Reference No:	<b>2025/62/90567/E</b>
Site Address:	107, Latham Lane, Gomersal, Cleckheaton, BD19 4AP
Description:	Formation of new vehicular access
Recommending Officer:	Elenya Jackson

**DECISION - REFUSE**

## OFFICER REPORT

PROPOSED ELEVATION

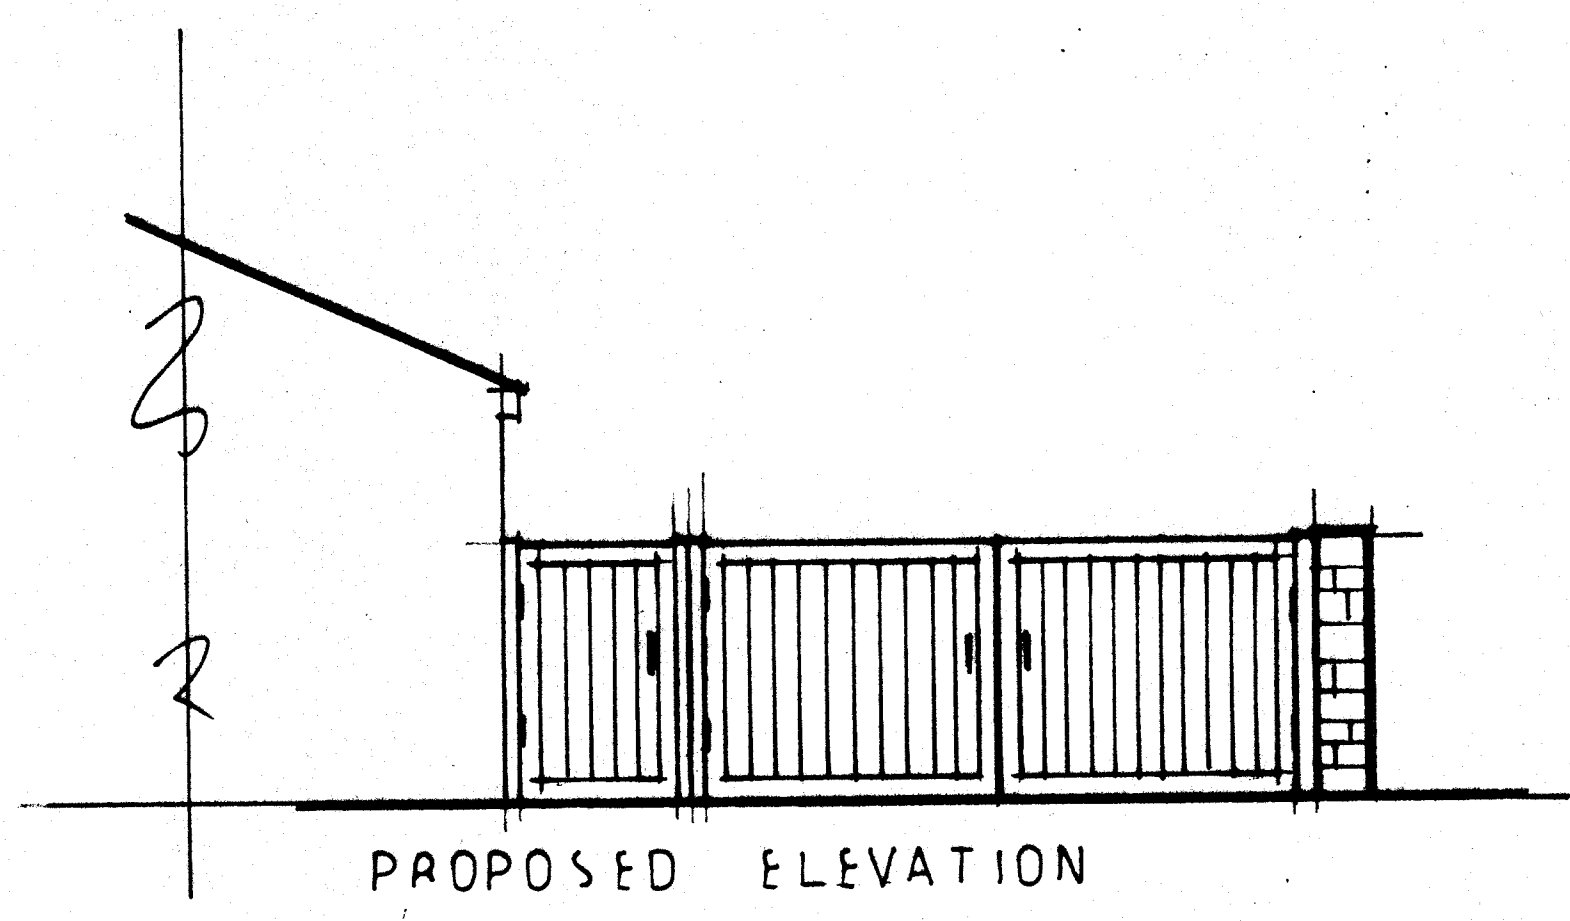
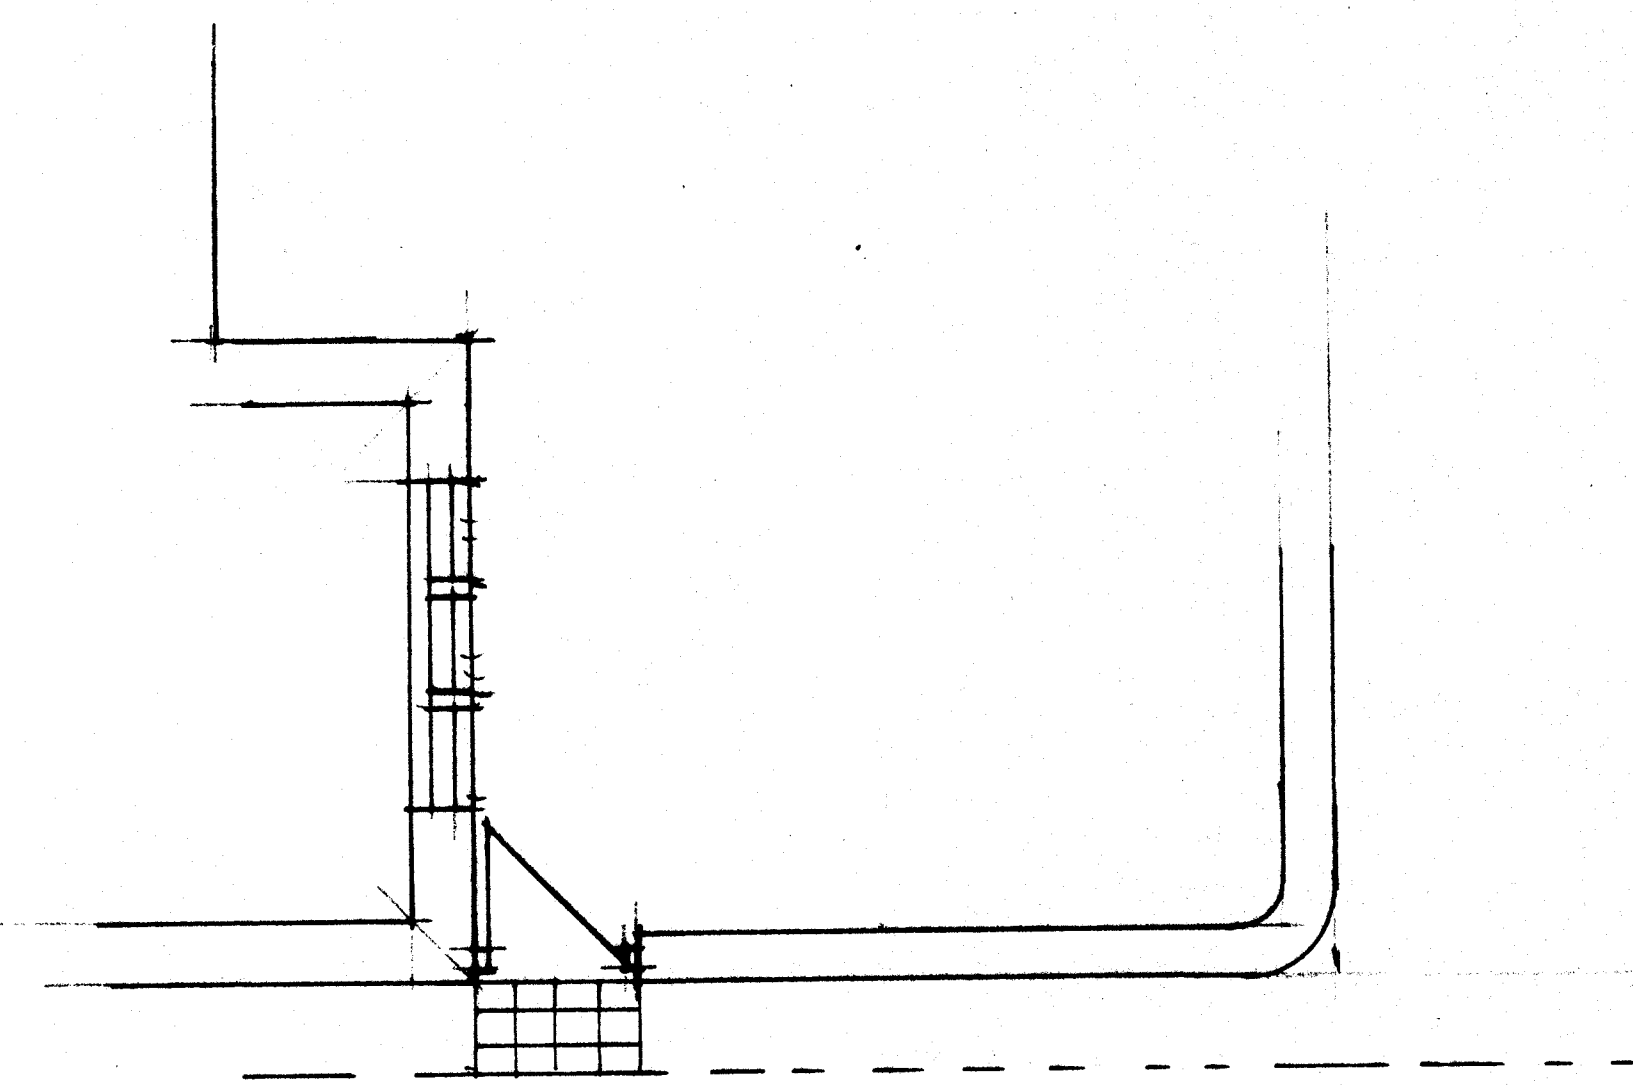
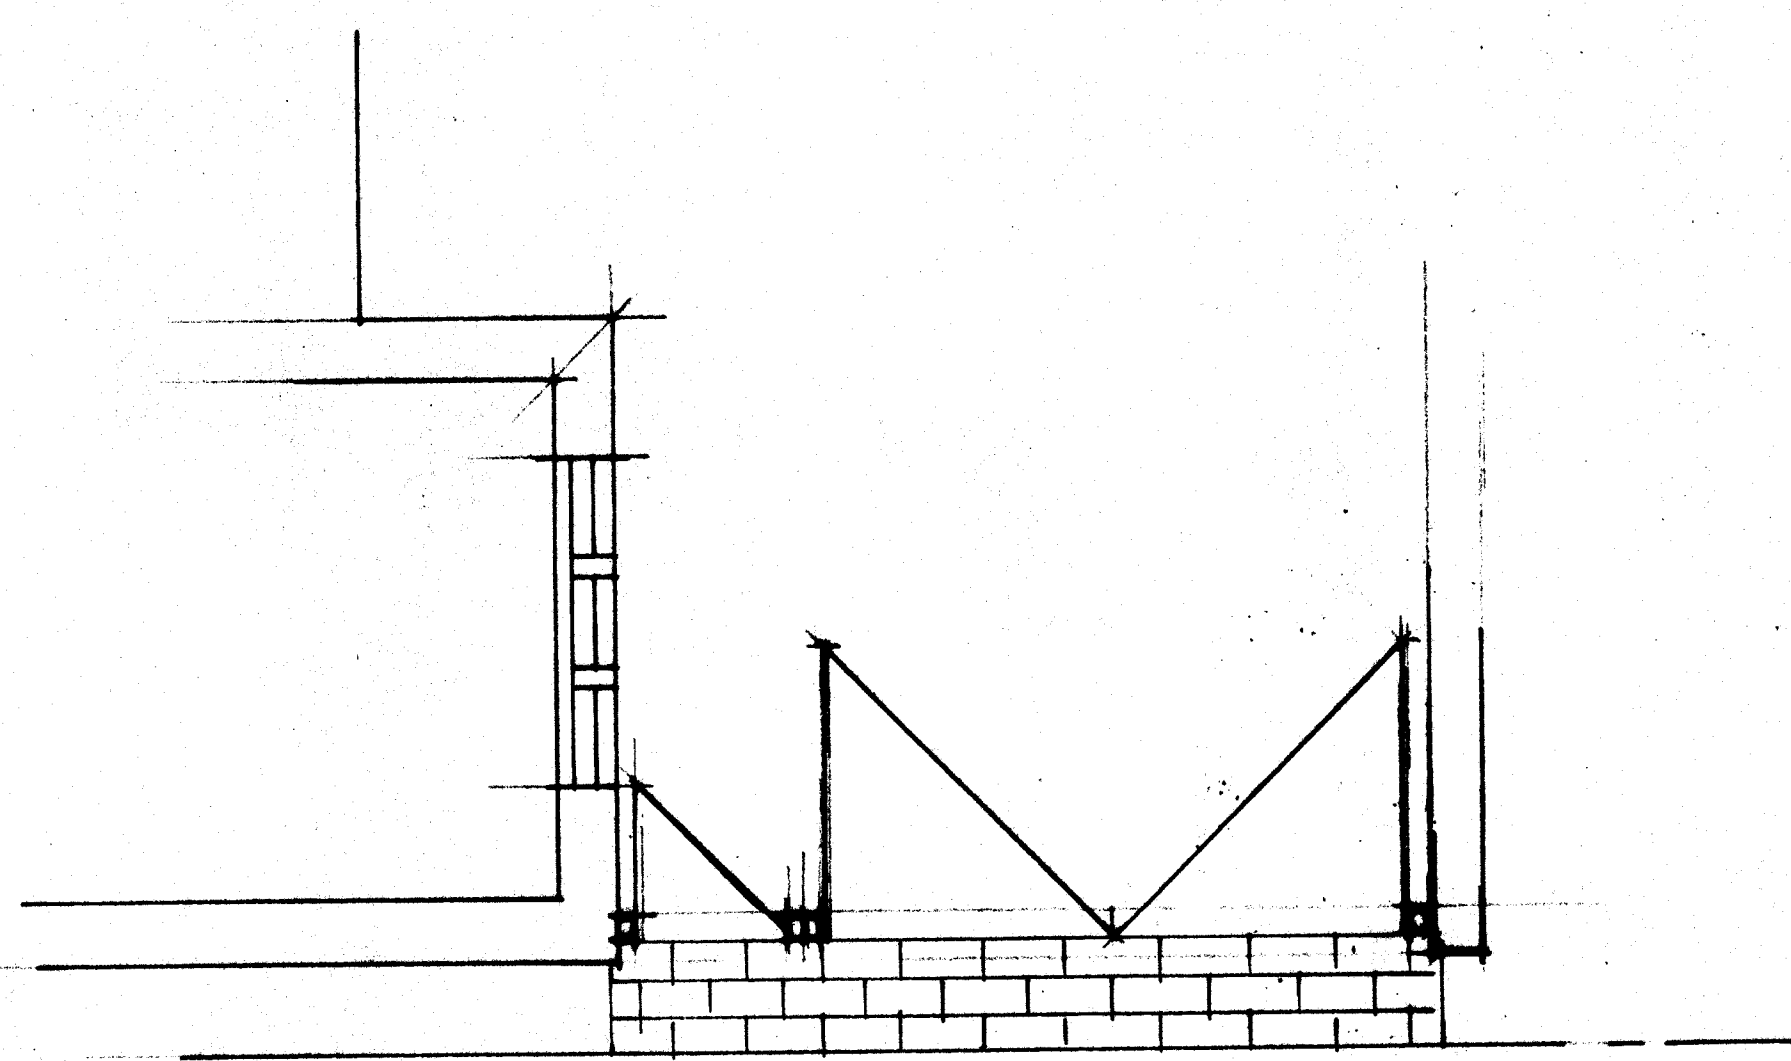
The formation of a vehicular access would not result in the addition of any projection or increases in height. However, the access is facilitated by removing the boundary wall and amenity space to the rear of the property with the formation of hard standing to create the parking provision.

The removal of the wall will alter the appearance of the site. Its removal to provide parking is similar to existing works that can be found within the street scene and as such is not out of character. There is a Listed Building opposite the site; however, officers consider that the creation of a vehicular access would have no impact on the significance of a Listed Building and therefore no public benefits are required to be demonstrated in this instance.

SITE PLAN
1:500

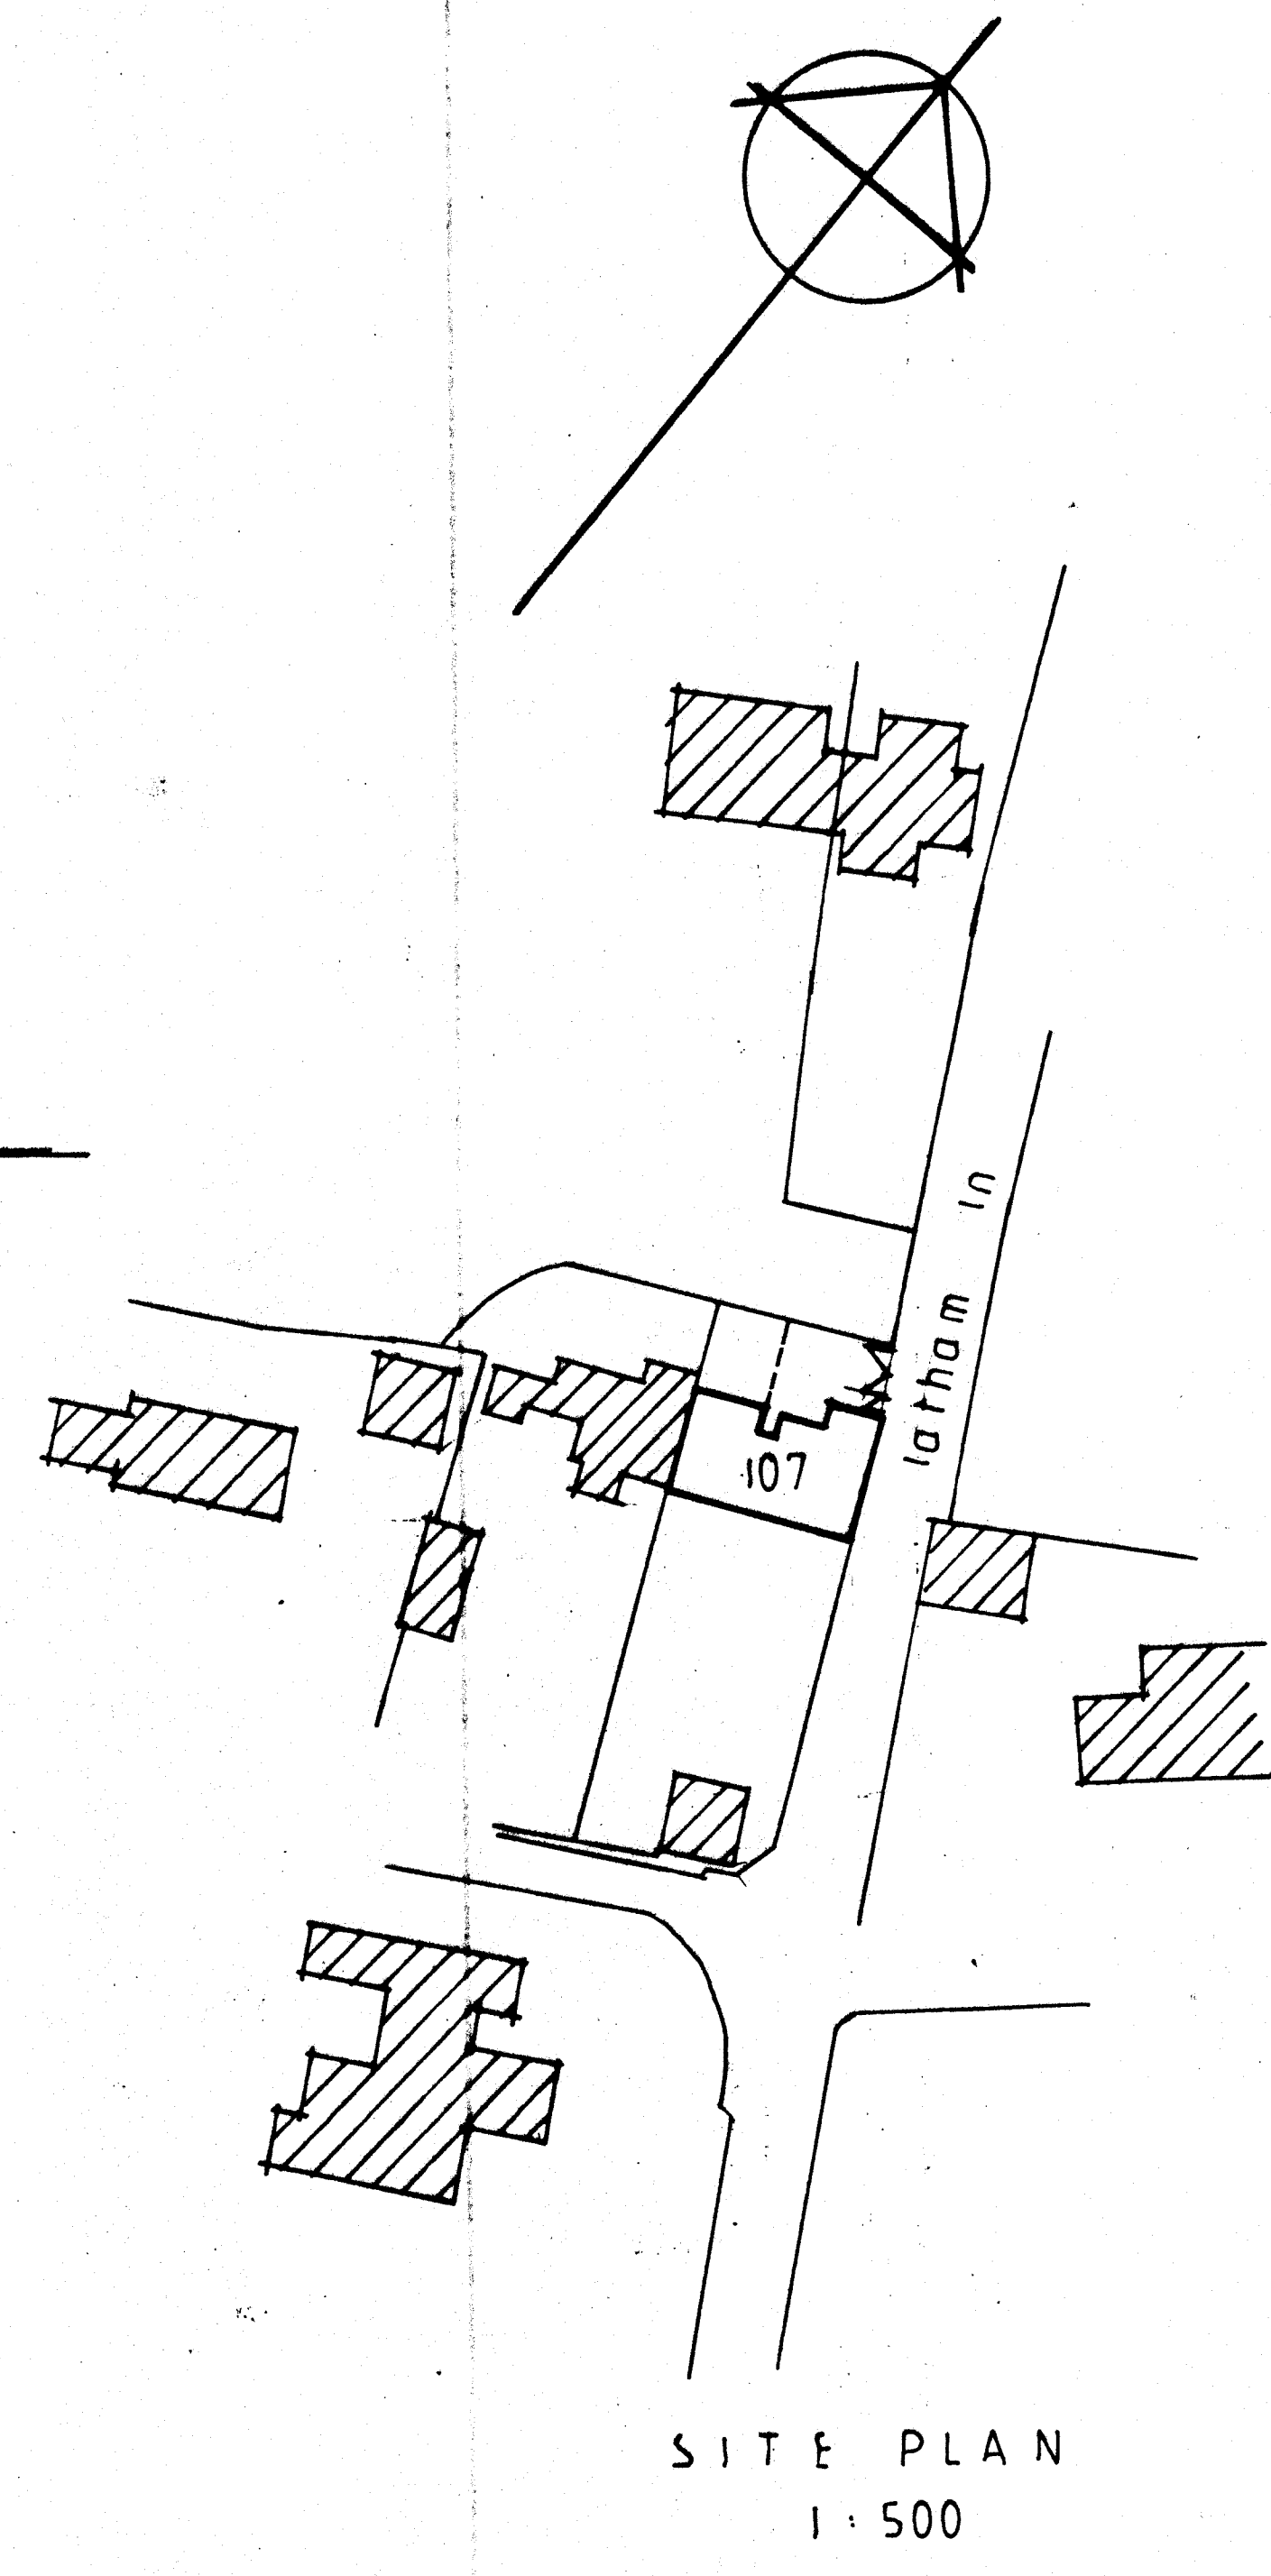
KC Highways DM were informally consulted on the application due to the property being located on an adopted highway. It was the highways officer's recommendation that the access gates would need to be set back in the plot by 2.4m and visibility splays shown. However, it was considered that acceptable visibility splays would not be able to be obtained in this instance due to the location of the host dwelling and vegetation outside of the applicant's ownership.

Therefore, the KC Highways Officer would object to the proposal.

The application has been reviewed by KC Highways and cannot be supported as sufficient visibility splays cannot be provided on site. This is due to the location of the host dwelling and the presence of vegetation which is outside of the applicant's ownership.

1. The proposal would fail to provide adequate visibility splays for access onto an adopted highway, and as such, has the potential to have a detrimental impact on highway safety, contrary to Policy LP21 of the Kirklees Local Plan along with Key Design Principles 15 & 16 of the House Extensions and Alterations SPD.
